Reference No:	2025/62/91012/W
Site Address:	1, Mount View Road, Hepworth, Holmfirth, HD9 1JA
Description:	Alterations and extension to lower ground floor garage to extended living accommodation with terrace above and alterations
Recommending Officer:	Molly Storer

DECISION – CONDITIONAL FULL PERMISSION

Officer report

Drg. no.	Rev.
298-25-PL02	A

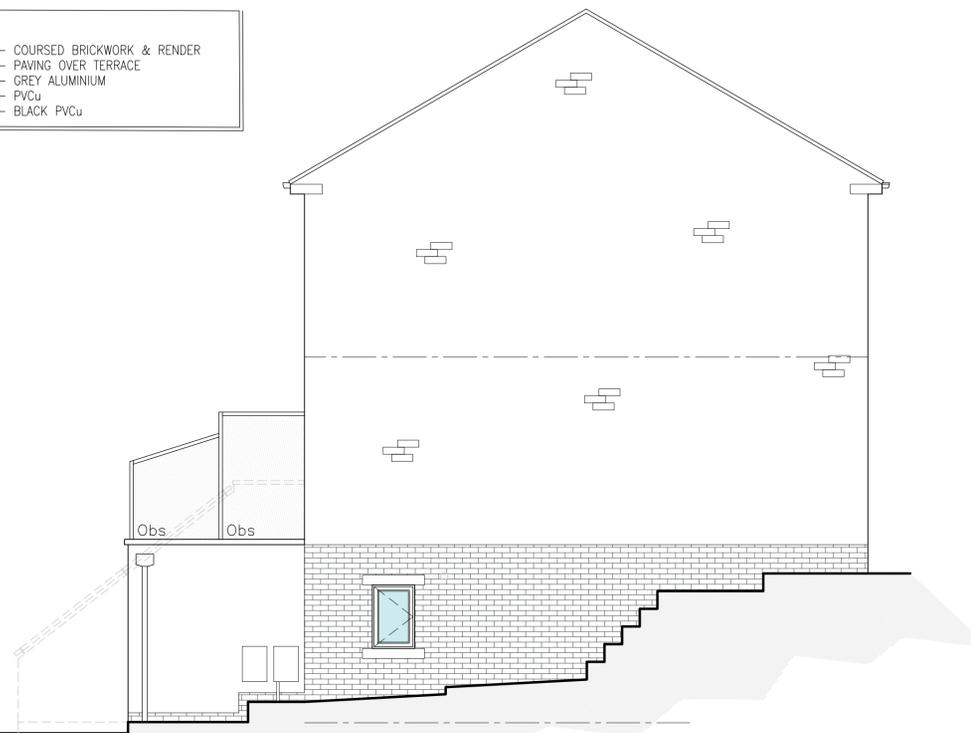
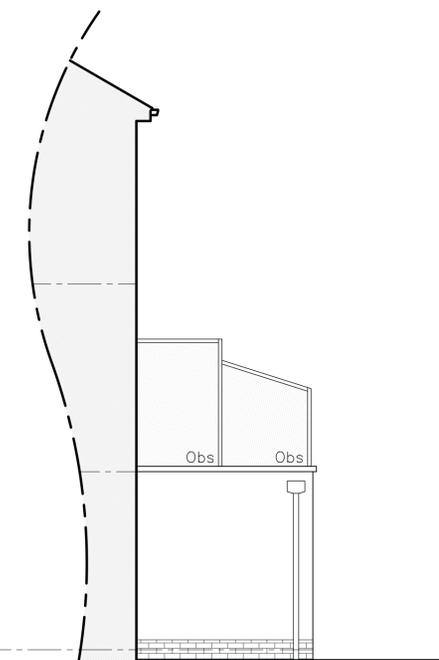
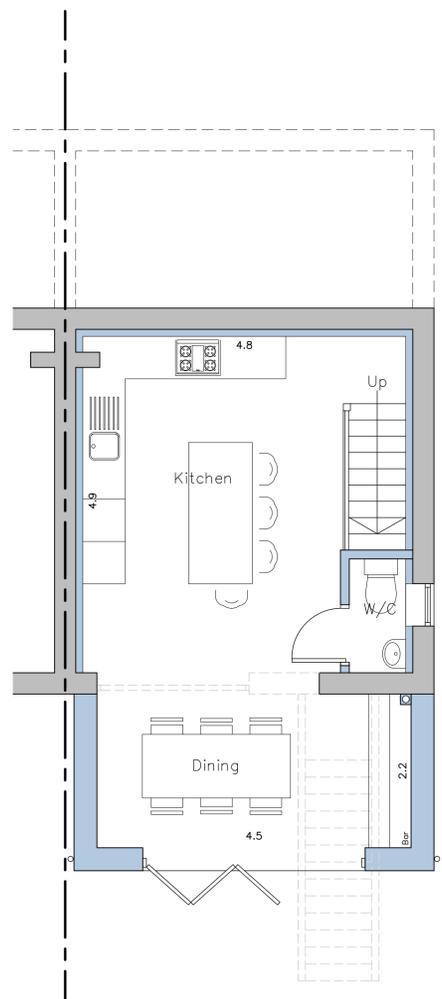
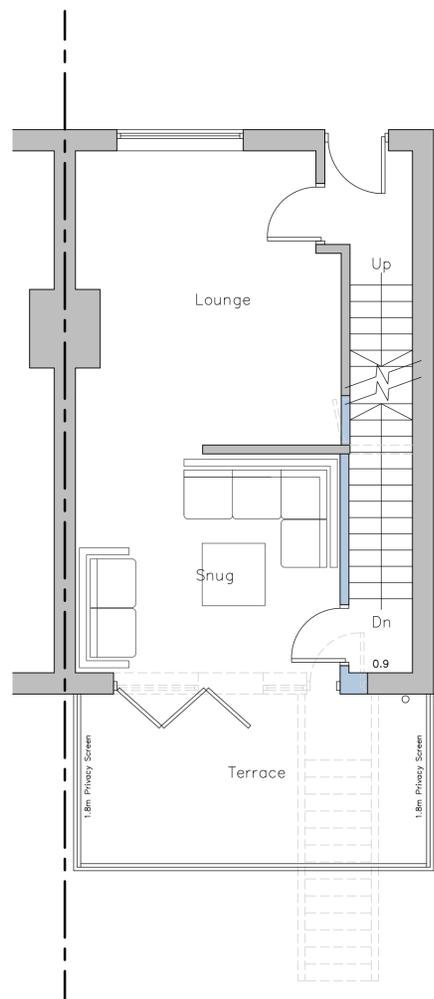
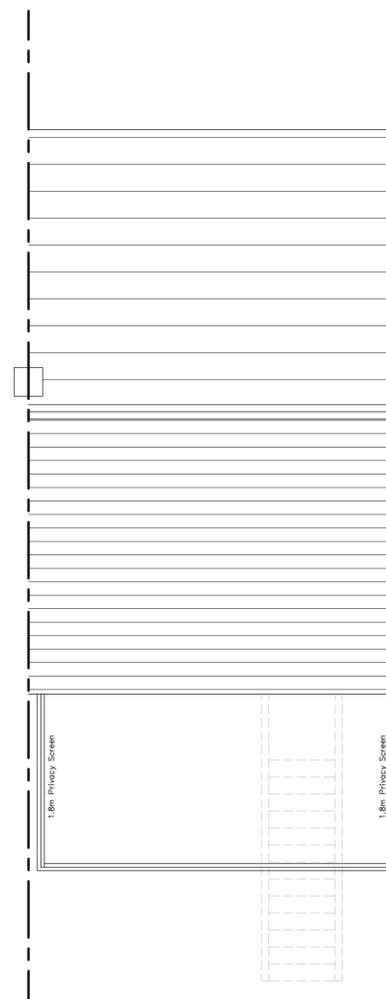
3. The 1.8m high privacy screen as shown on the northeast and southwest side elevations of the balcony hereby approved on submitted plan DRG No. 298-25-PL02 shall be installed to the side elevations of the balcony as shown on that plan, before the balcony is first brought into use. The 1.8m high privacy screens shall thereafter be retained.
